Tel: 01895 250230
Case Officer: James Wells
Email: JWells@hillingdon.gov.uk
Date: 6th December 2021
Our Ref: 46943/PRC/2021/217

RE: Three Storey Rear Extension, Two Storey Rear Extension, Single Storey Rear Extension and Loft Extension

SITE: 44 Mount Pleasant Ruislip

12 FIRST FLOOR PROPOSED
PLAN
SCALE 1:100 @ A3

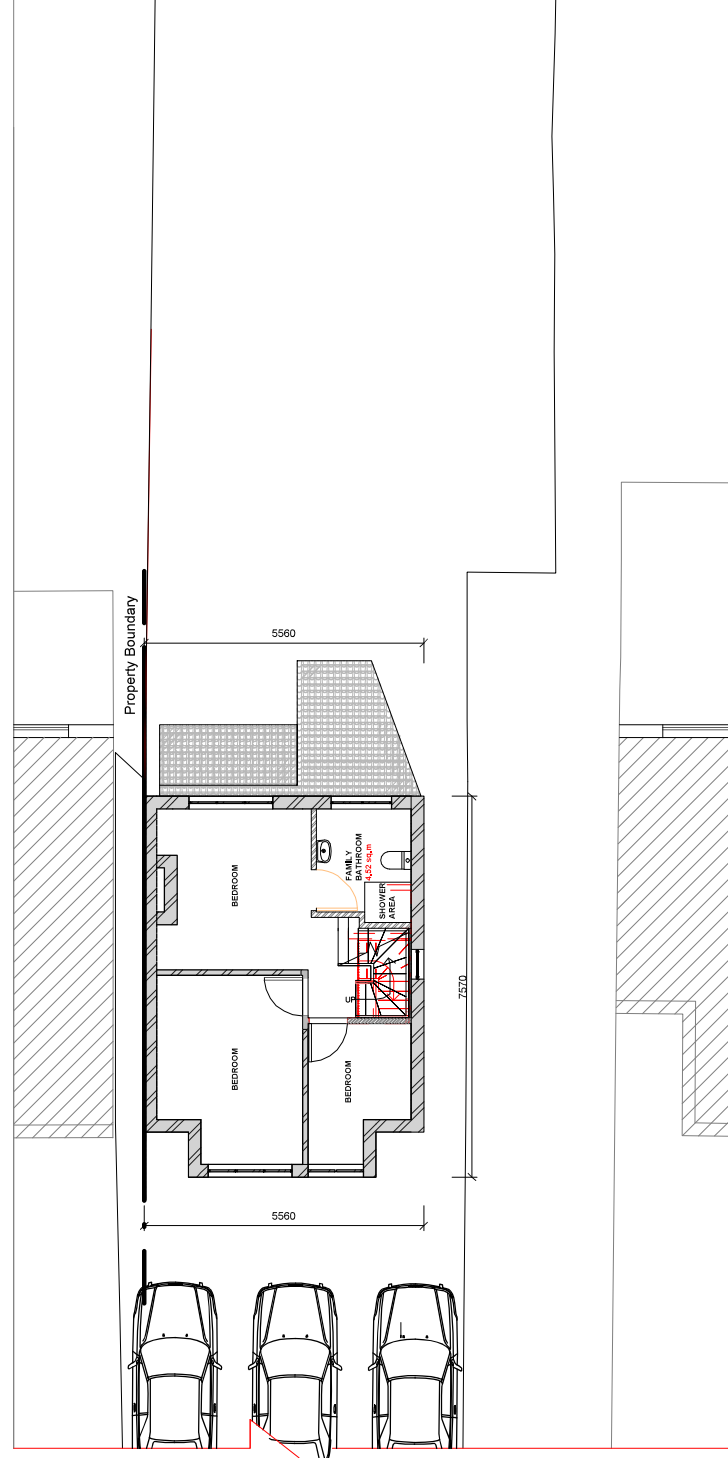
The three storey rear extension would have a flat roof and be approximately 4.8m wide and project approximately 2.2m from the main rear wall of the property. The two storey rear extension would have a flat roof with two roof lights and be approximately 4.9m wide and project approximately 4.65m from the main rear wall the property. The single storey rear extension would have a flat roof with a roof light and be approximately 5.2m wide and project approximately 10.9m from the main rear wall of the property.

The design and siting of the proposed roof extension at the front of the property, the three storey rear extension, the two storey rear extension, the single storey rear extension and the loft extension would cause significant overshadowing and loss of light to adjacent properties. They would have an adverse impact on the amenity, daylight and sunlight of adjacent properties, would be overbearing and adversely affect the outlook from neighbouring properties. The proposal therefore cannot be supported by the Council.

14 ROOF PROPOSED
PLAN SCALE 1:100 @ A3

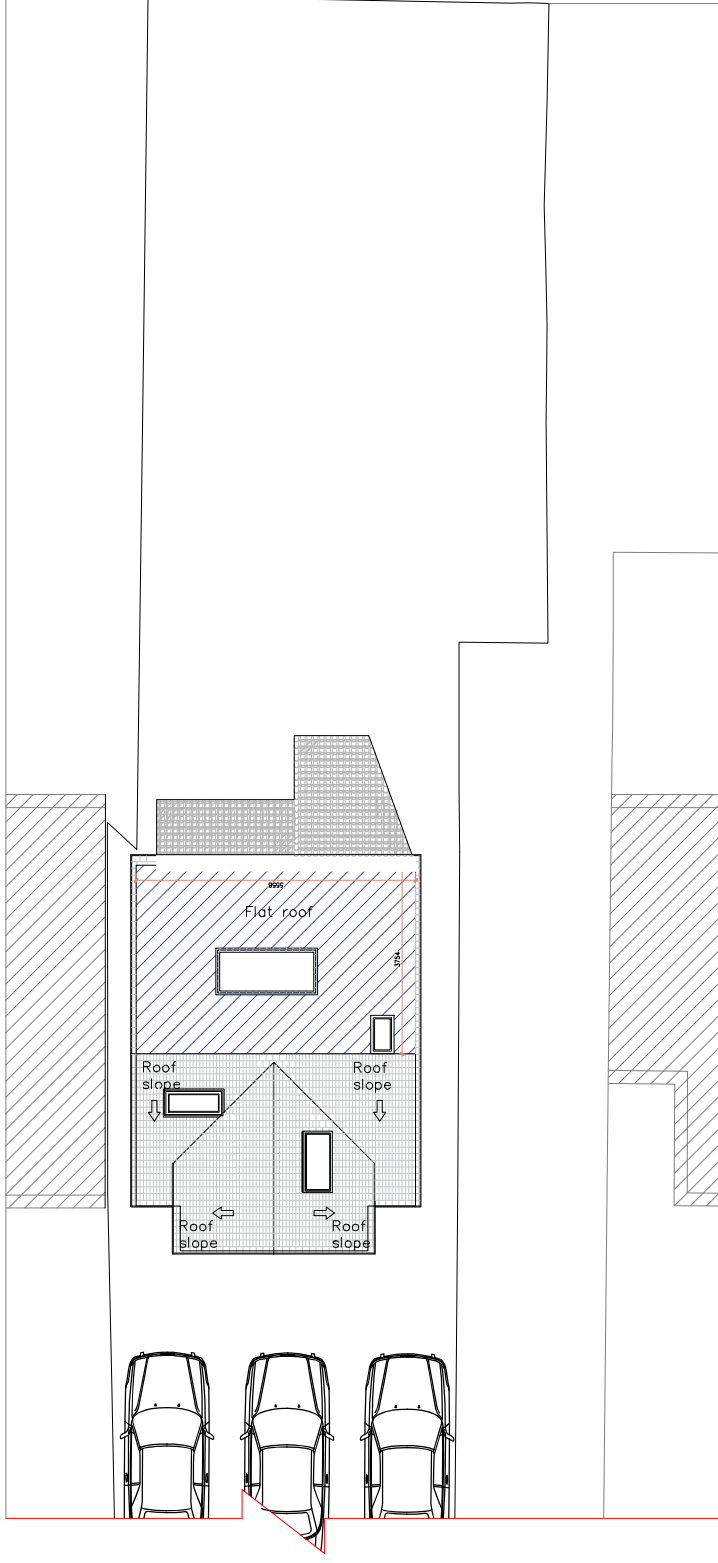
The loft extension will change the existing hipped roof into a gable end roof with a central 'ridge' that runs from side to side of the property. The front section of the roof would slope down from a maximum height of approximately 7.9m (the existing ridge height is approximately 6.54m) and the rear section of the roof would be flat. The height of the roof at eaves level would be increased from approximately 5.04m to approximately 6.4m.

The proposed roof extension at the front of the property, the three storey rear extension, the two storey rear extension, the single storey rear extension and the loft extension are considered contrary to Policies DMHB 11 and DMHD 1 of the Hillingdon Local Plan: Part Two - Development Management Policies (2020) and could not be supported by the Council. The proposed extensions would not be subordinate to the scale of the original house and their design would have a significant, adverse impact on the character and appearance of the original house and the street scene.
